From: Amanda Scholes on behalf of Planning.Responses
Sent: 09 February 2018 09:16
To: Planning Scanning
Subject: FW: 97 Barnham Road, Eastergate - EG/107/17/DOC

Number
S17-03-01 G

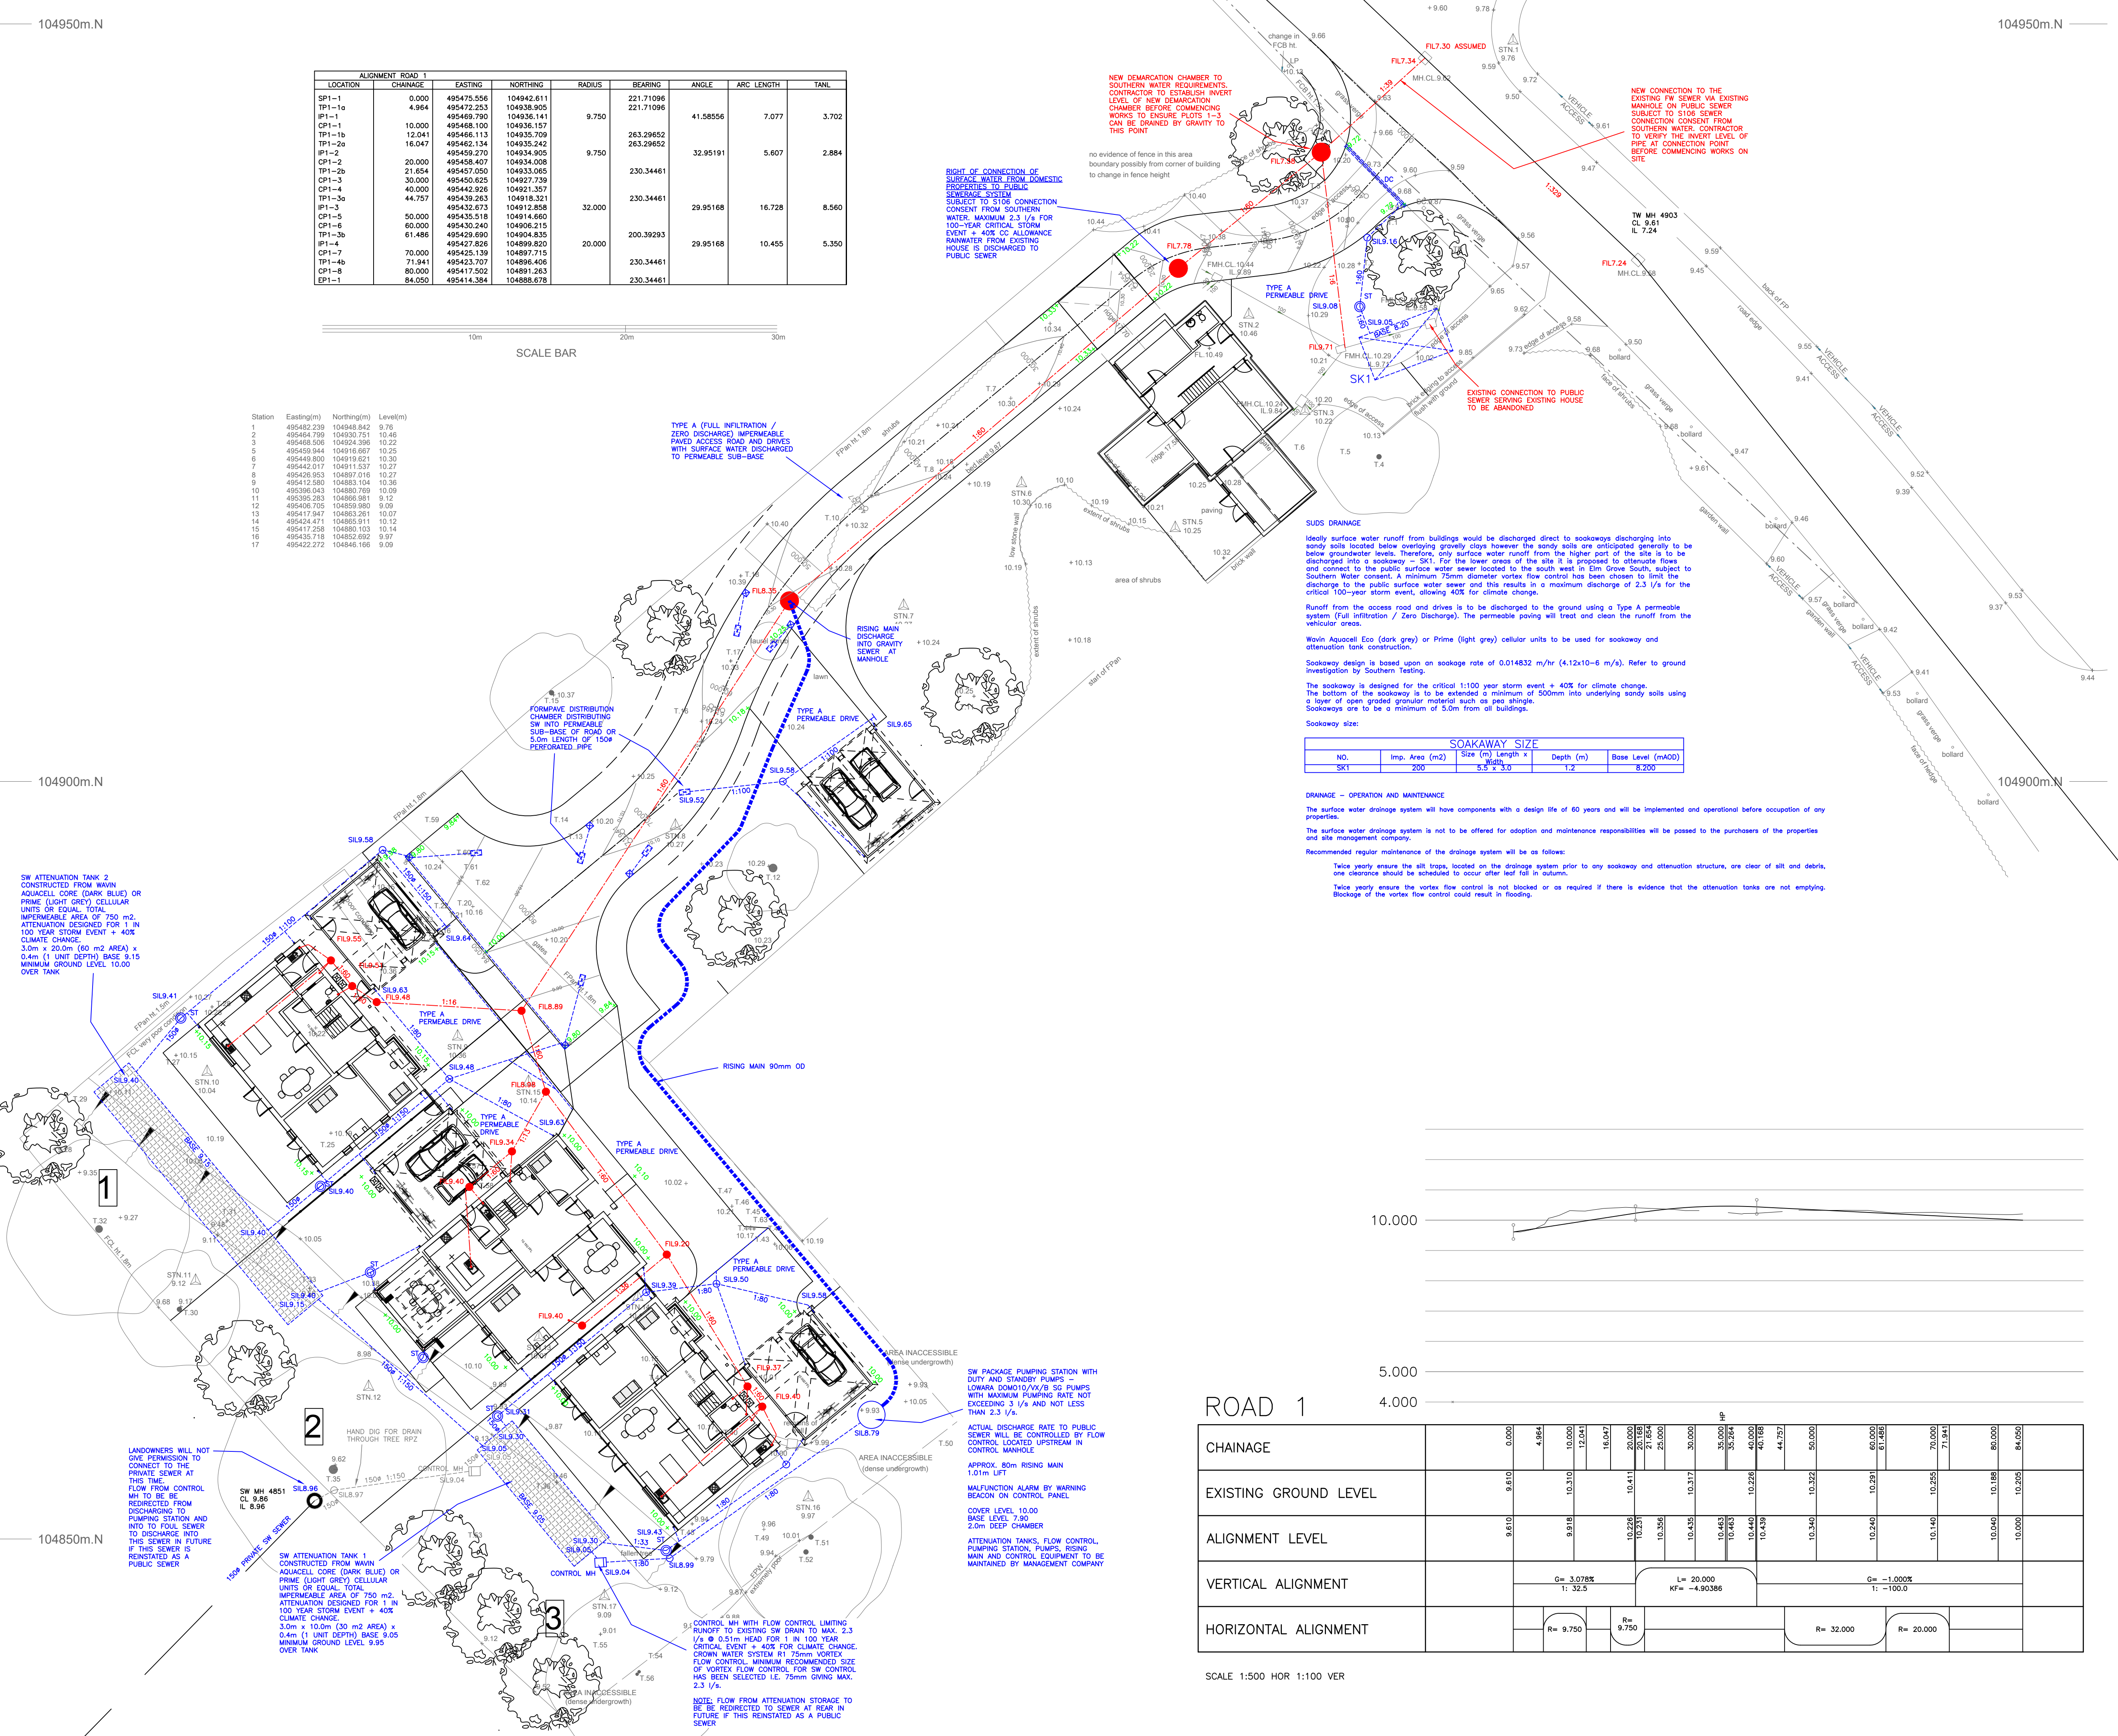
1. The proposals now show the rising main discharging directly into the foul manhole, rather than via the length of new gravity sewer/discharge manhole, previously detailed. Confirmation is required from Southern Water that they have agreed this arrangement. Please also specify the rising man connection level into the manhole (again Southern Water will need to also agree this level).
2. Provide construction detail drawing for the pumping station.
3. The actual pump rate must be restricted to no greater than 2.3 l/s as per Southern Waters requirements. Therefore the drawing notes need amendment (currently says no greater than 3l/s.
4. Specify rising main pipe material and bedding to ensure adequate protection from vehicular loadings.

I have been asked by our enforcement officer to check with you as to the location of the SW Attenuation Tank no. 1. On the submitted plans it is shown approx. 3m from the rear of plot 1. However, we were sent a plan (attached) back in April by Sigma Homes that suggests it is actually 5.1m from the rear of plot 1. Can you seek clarification as this needs to be correct on the submitted plans.

Rose – They have now shown the SW Attenuation Tank no. 1 in the correct place
